RE: Submission in Response to EIS on the Proposed Yarrabee Solar Farm - Application No SSD 9237

Narrandera Shire Council ('NSC') appreciates the opportunity to respond with comments on the EIS for the proposed 900 MW Yarrabee Solar Farm ('Project'), located 23km south-east of Narrandera.

Figure 21 Proposed Access Routes

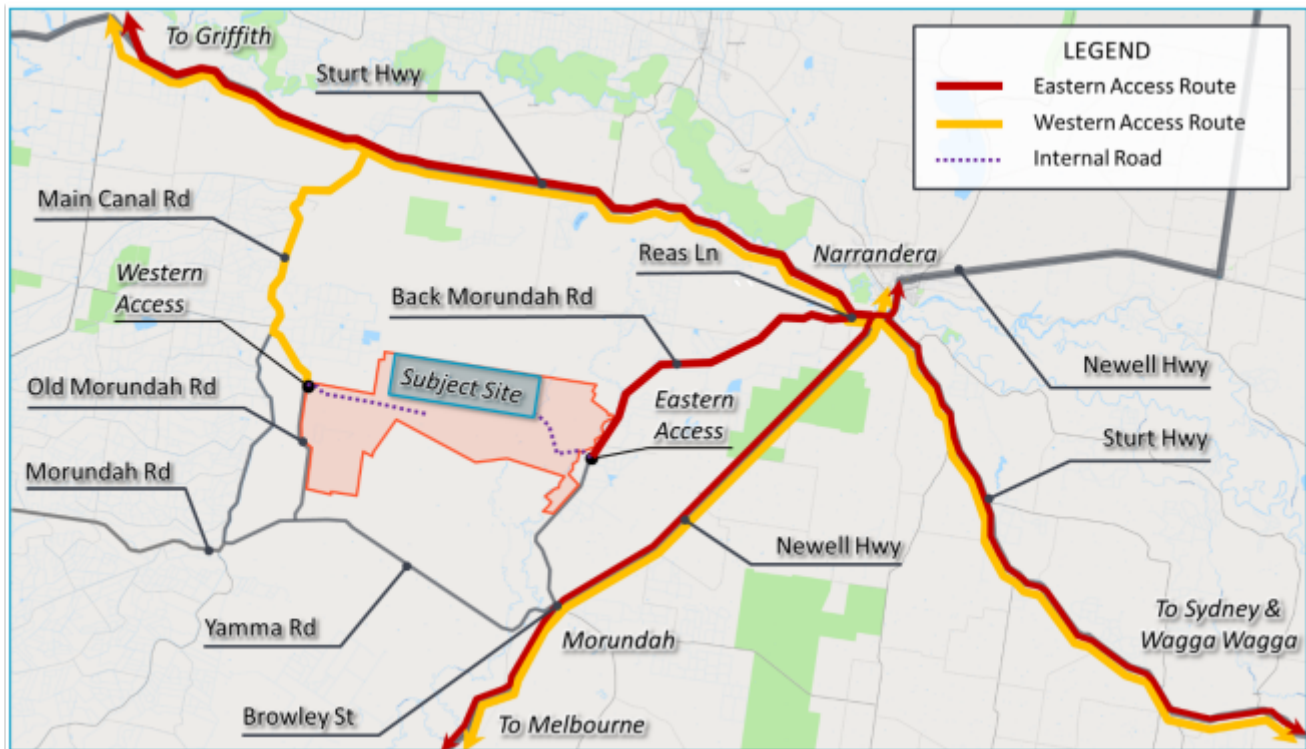
Council notes heavy vehicles are to enter and exit the site via the Western Access Route (via Main Canal Road); light vehicles and buses will access the site via the Eastern Access Route (via Back Morundah Road). It is also noted that there is restricted access for B-doubles on Main Canal Road and Old Morundah Road.

Reas Lane and Back Morundah Road are sealed roads with varying quality of gravel substrate and seal, primarily designed to cater for low volume local traffic. It is considered there is a high likelihood this development will increase the deterioration rate of these roads that would not otherwise be expected.

Due to the use of Back Morundah Road by local traffic and its status as a school bus route, it is considered that a certain amount of upgrading work will be required prior to construction commencing. The following condition should be included in any approval:

1. Upgrade of Back Morundah Road from the intersection of Reas Lane to 100m past the entrance of the solar farm:
 - Provide a minimum of 100mm compacted gravel (gravel to be minimum CBR 30 material)
 - Maintain 7m wide seal (currently 6m) with 1m gravel shoulder on either side
 - Provide a 20/14 seal
2. Reas Lane – Back Morundah intersection upgrade – BAR/BAL:
 - Design as per Austroad's standards for geometry
 - Provide a minimum 200mm compacted gravel depth (minimum CBR 30 material)
 - Provide a 20/14 seal
 - Line mark the BAR/BAL configuration up to 30m off the edge line of the road
3. Entry road to solar farm – Back Morundah road intersection – BAR/BAL
 - Design as per Austroad's standards for geometry
 - Provide a minimum 200mm compacted gravel depth (minimum CBR 30 material)
 - Provide a 20/14 seal
 - Line mark the BAR/BAL configuration up to 30m off the edge line of the road
